**PERKINS+WILL****MMC East Tower Expansion – City Design Comments**

To:	Al Green
From:	Jeffrey Keilman
Date:	February 20, 2018
Subject:	<b>MMC East Tower Expansion – City Design Comments</b>
Attachments	N/A

The purpose of this memorandum is to document and provide design team responses to the Design Comments provided by City of Portland Staff and comments made by the Planning Board on 01.23.2018.

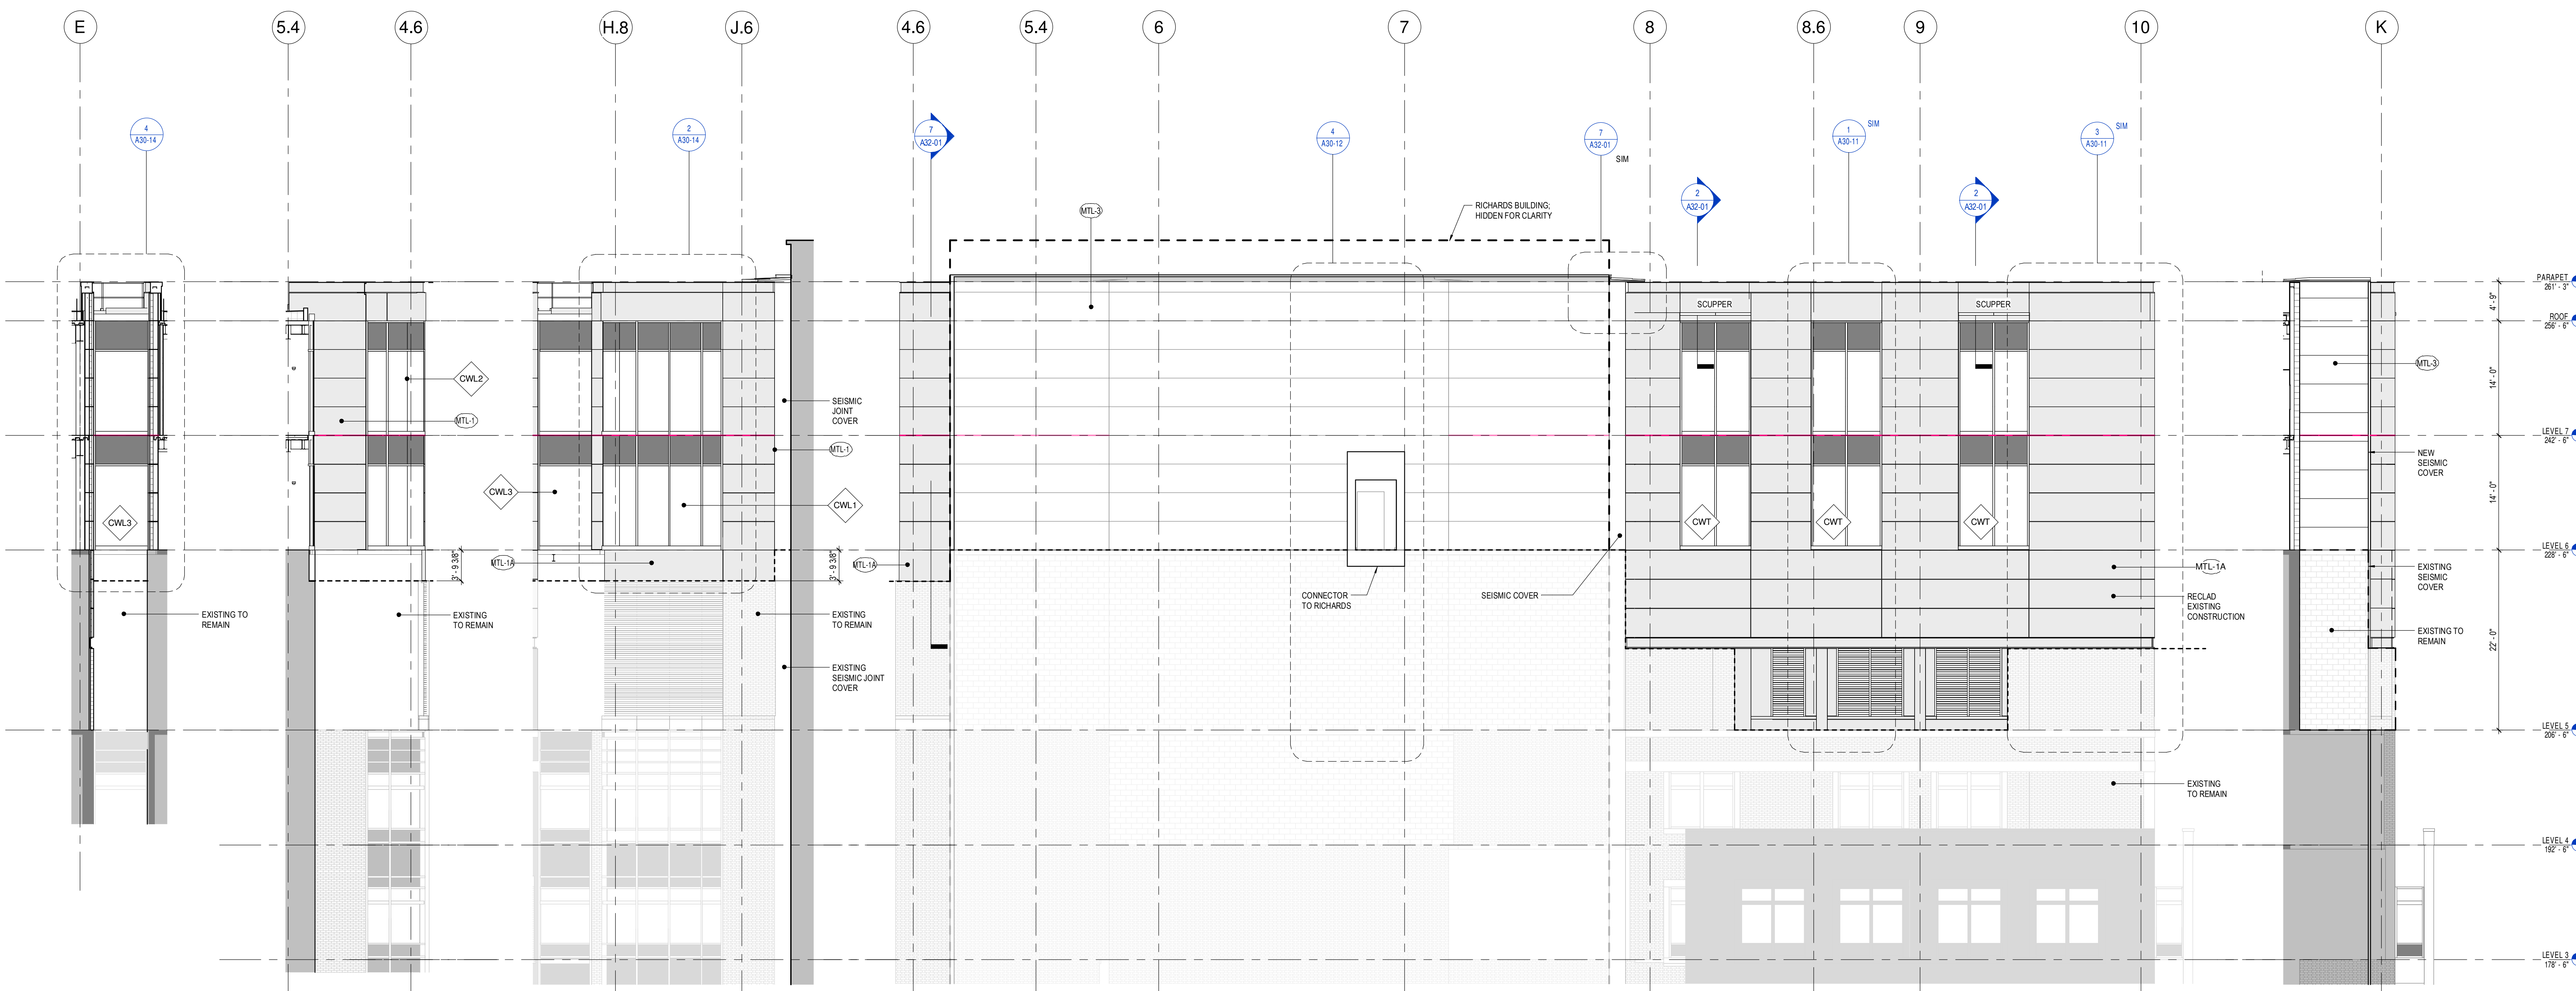
Mixed feelings about use of white panels - too sterile or stark contrast, not recessive enough? Provide renderings showing options for material choices, grey or silver were specifically mentioned

Address request for integration: Integration of existing building elements and new - looks like an addition

Additional Staff Comments: aligned with PB comment, continue to have some concern about the facade integration of the new and existing - especially in overall facade composition, proportion, and articulation. The existing building has a high level of articulation while the proposed new is much more minimal. Please clarify where new metal panel is proposed and where existing to remain and the strategy around getting those to match or blend. Staff suggest you consider articulation strategies in the new section that address these integration concerns whether that is a horizontal band, dimensional elements, color or other strategies.

The design team appreciates the comments and understands the concerns. After careful consideration and reviewing past designs and studies, MMC and the Design Team feels strongly that the decision to continue the existing white metal panel on the East Tower expansion is still the correct design decision. This decision is based first on the fact that all the existing conditions on, surrounding, and below the East Tower utilize white metal panels. This is highlighted in the context photos of campus indicating areas of white panels existing including the bays and cap of East Tower,

the ED Entrance, and the Bean connectors and addition (see Figure 1). Along with the use of metal panel, the continuation of curtain wall from the existing reveals in the mass are continued up into the new addition, effectively helping to stitch the buildings together. Deviations in materials from the existing campus palate will create more discrepancy of new versus old.

**1 SOUTH - ELEVATION**  
1/8" = 1'-0"

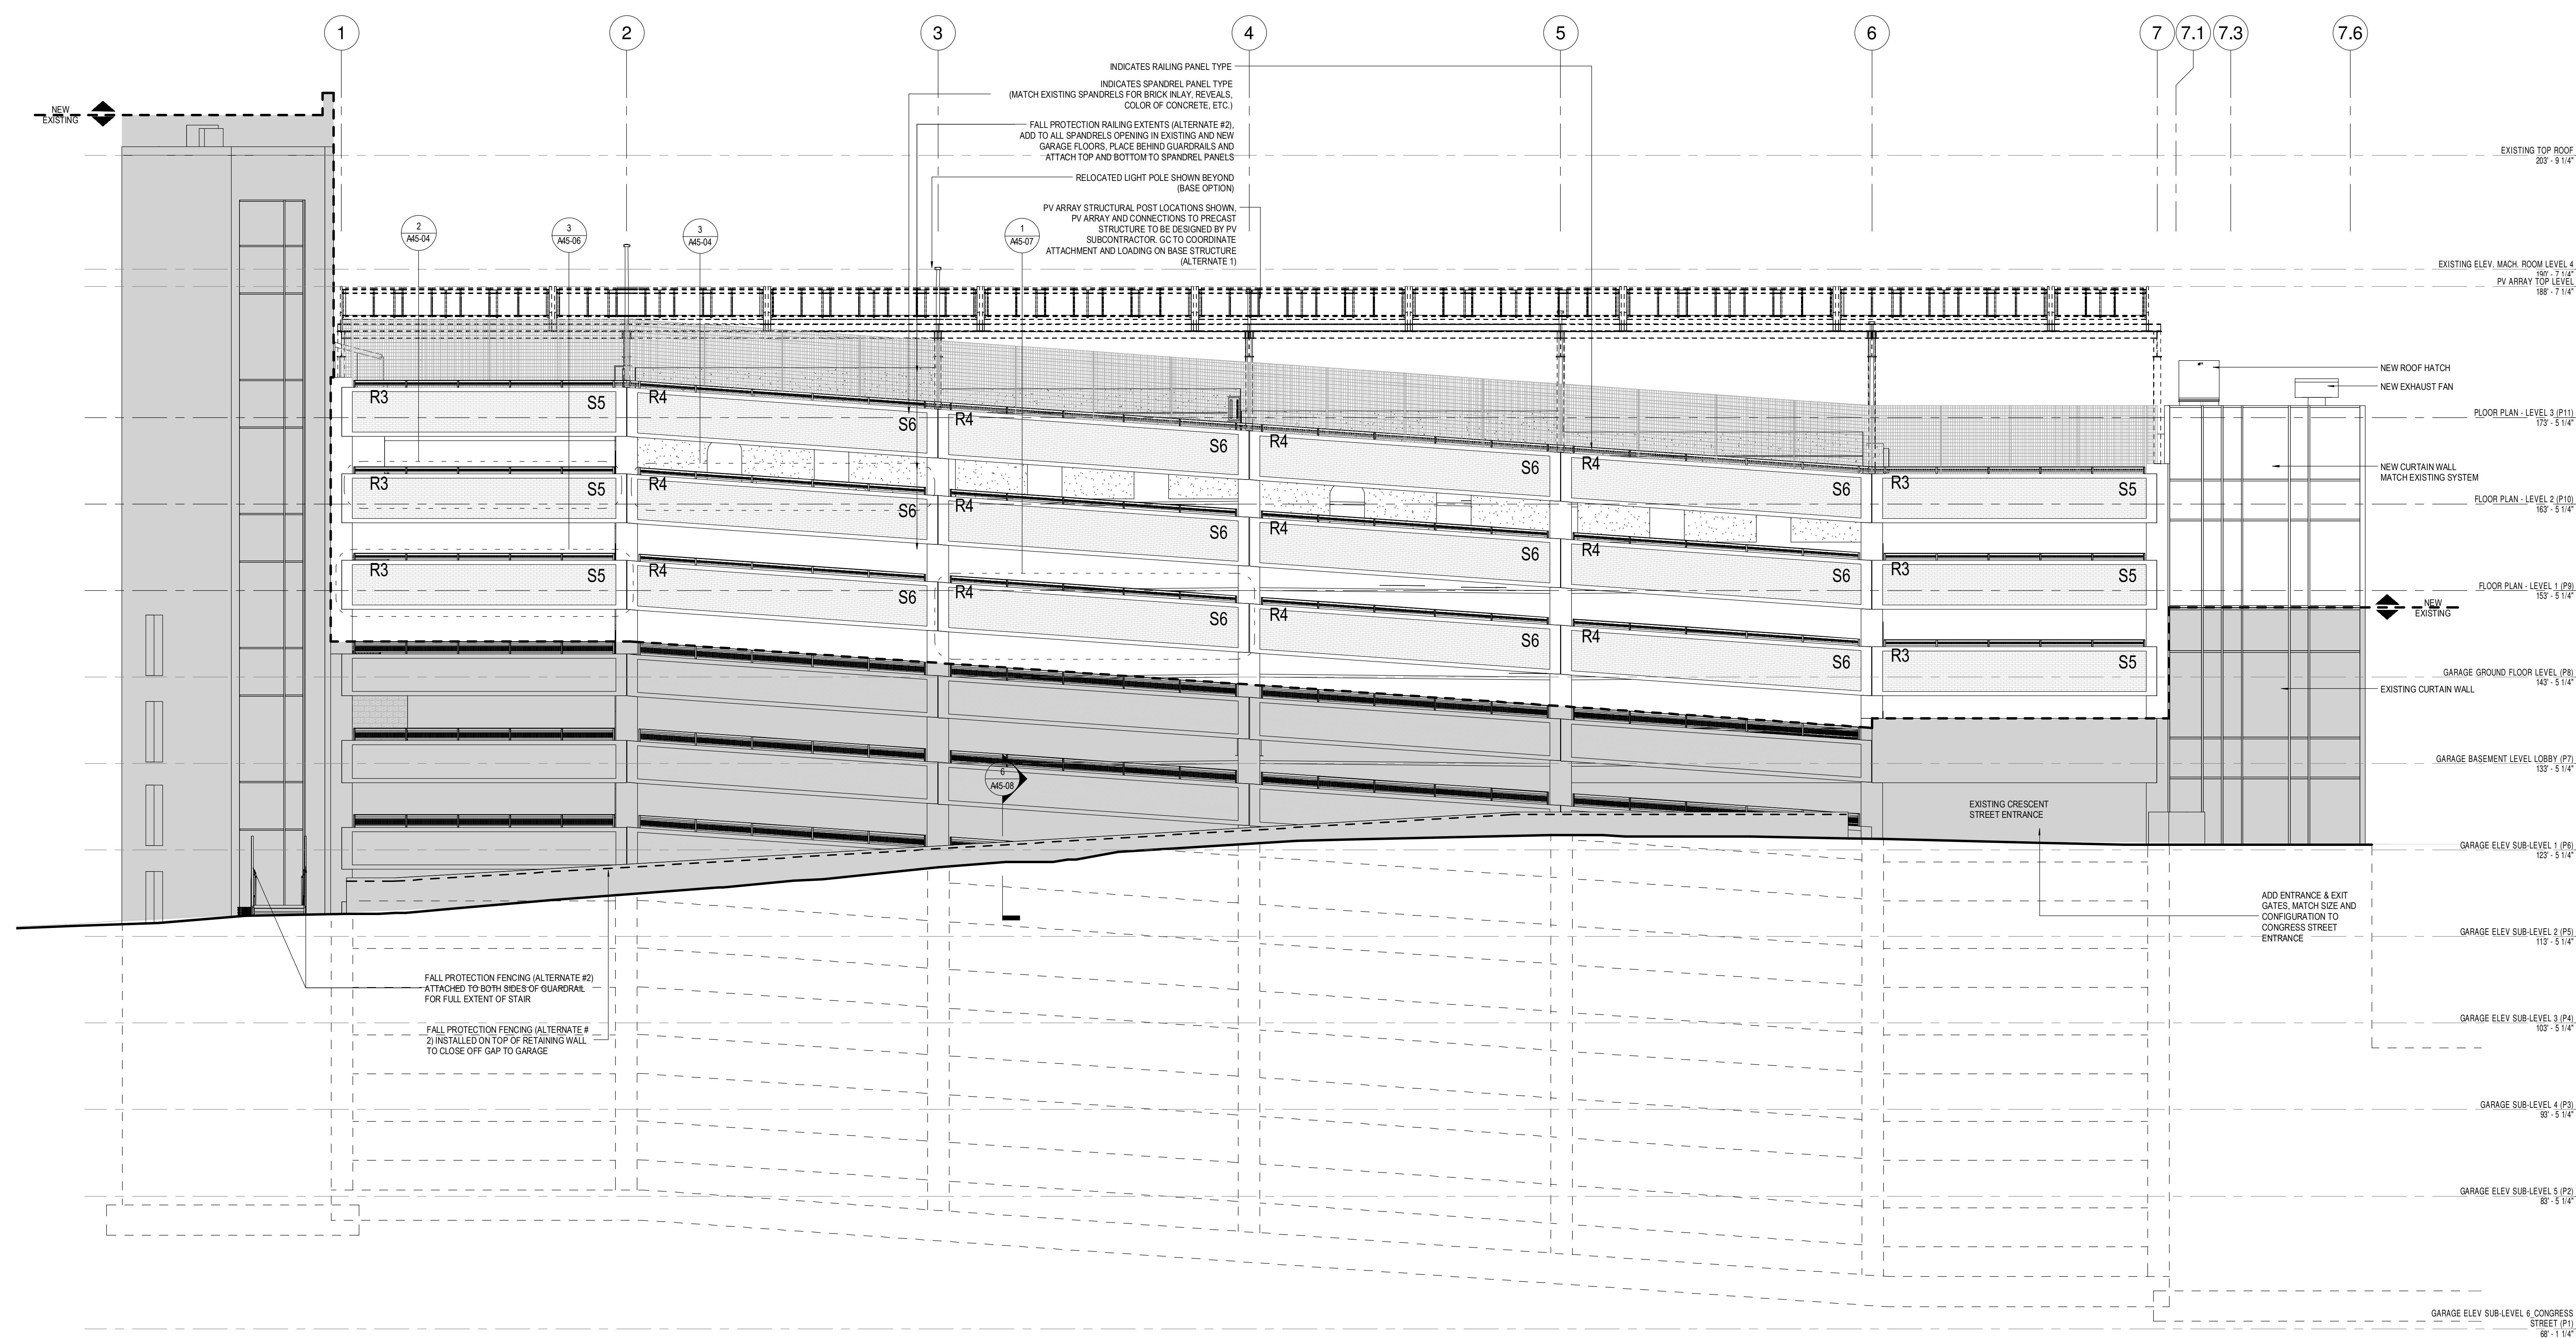
Concerns with parking garage design - rooftop fence quality, facade improvements

City Staff: There are two opportunities to update or improve the design character of the garage - the fall protection fence, especially on the top level, and the metal screens.

The existing fall protection fencing on the Visitor Garage is planned to be relocated to the upper level of the addition. Photos have been provided that indicate the details of the system (Figure 4). The current system is a tight mesh that is painted white with limited vertical supports as required to meet the programmatic requirements of a fall protection system. Fall protection requires that the element be a tight mesh to limit abilities for individuals to easily climb the system, providing greater security. The system as currently installed has a minimal visual impact.

The current screens on the garage are a white grid that aims to add articulation and reduce the scale of some of the larger proportional elements of the garage. The addition replicates this design element to further refine and connect the new with the old so as to eliminate any discrepancies between the phases.

The garage is an open, naturally ventilated garage and the percentage of open air needs to be maintained or else the garage will not meet code.
